INFRASTRUCTURE NSW
Level 12, 19 Martin Place
Sydney NSW 2000

**Powerhouse Parramatta (SSD-10416)
Request for Response to Submissions and Additional Information**

I refer to your Response to Submissions (RtS) dated 8 October 2020 and additional information provided on 3 November in relation to the State significant development application for the Powerhouse Parramatta (SSD-10416).

Sheet Title
Tree Retention and Removal Plan

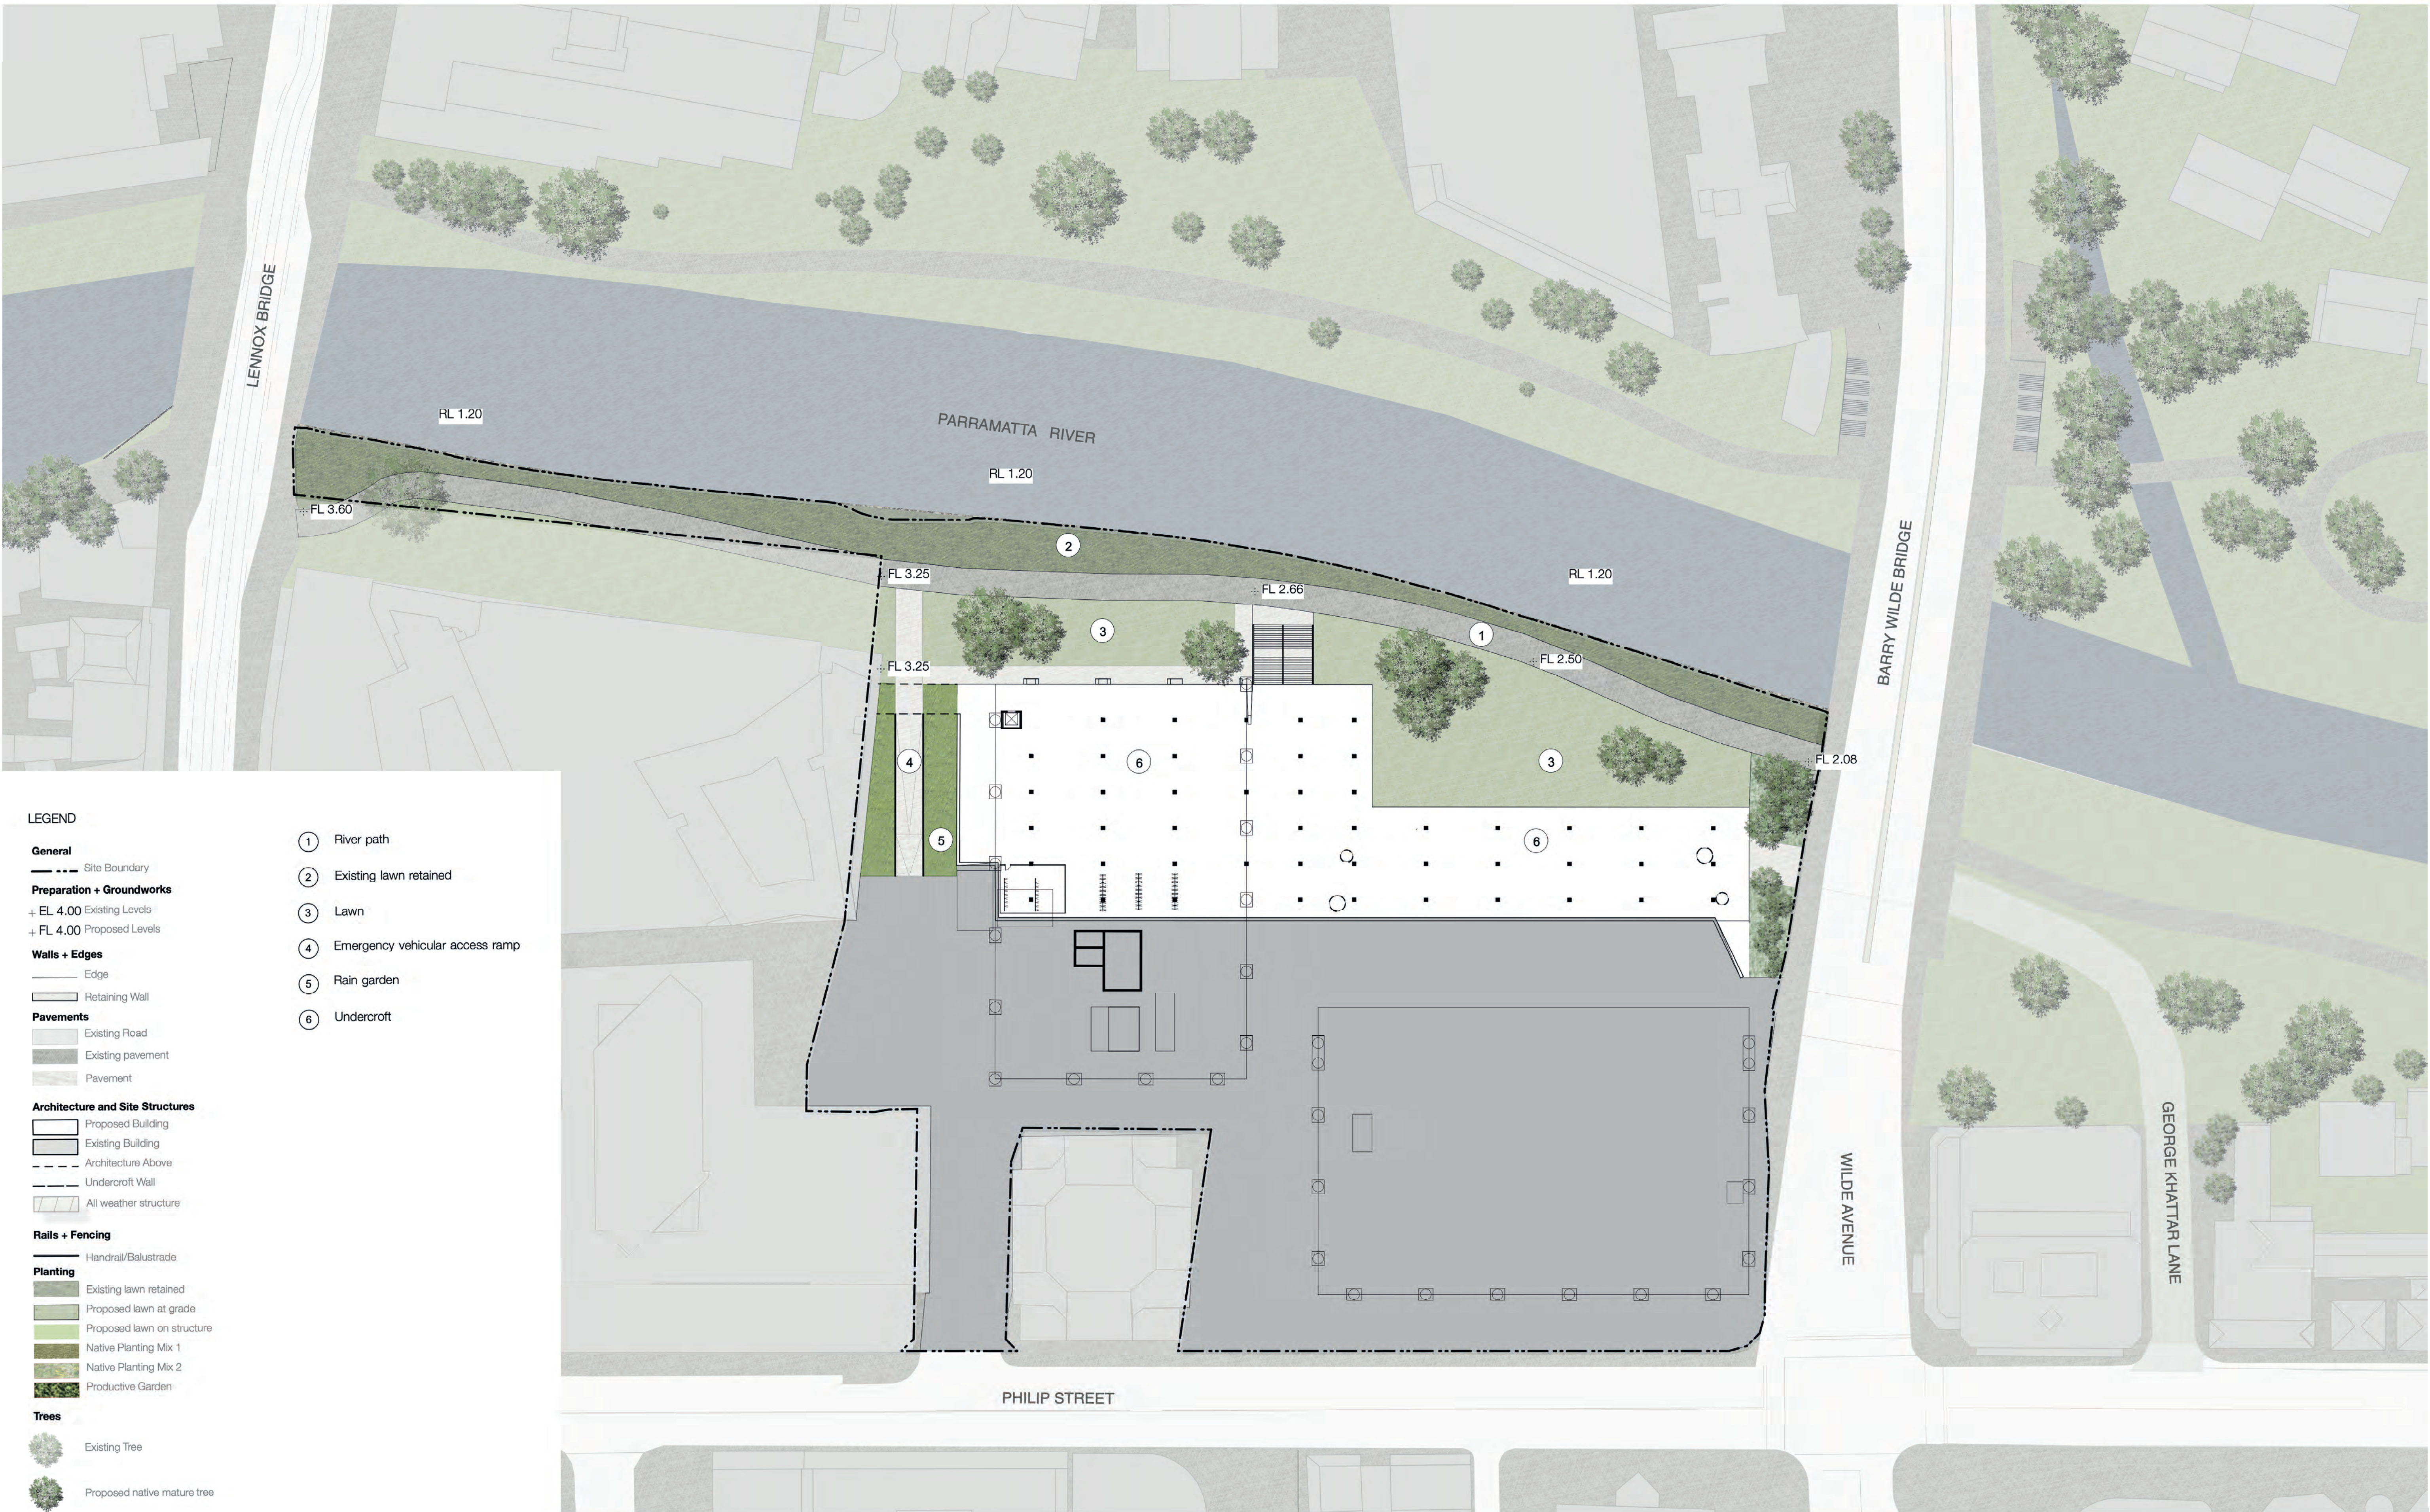
- Provide a copy of the Willow Grove Conservation Management Plan, by Form Architects, 2017 referred to in the Statement of Heritage Impact.
- Update the tree removal/retention plan (Drawing LD_DA_30-03) to take account of the retained tree included in the RtS and trees retained in response to points 6 and 7 of this letter.
- Confirm the height of the east and west buildings as measured above ground level (and taking account of the RtS) as the heights provided in the EIS (page 46, table 3) appear inconsistent with the plans.
- Confirm the dimensions of the signage zones and provide justification for their size with reference to Section 5.5 of the PDCP. Alternatively, consider removing the signage zones and reserving signage for consideration as part of future DA(s).
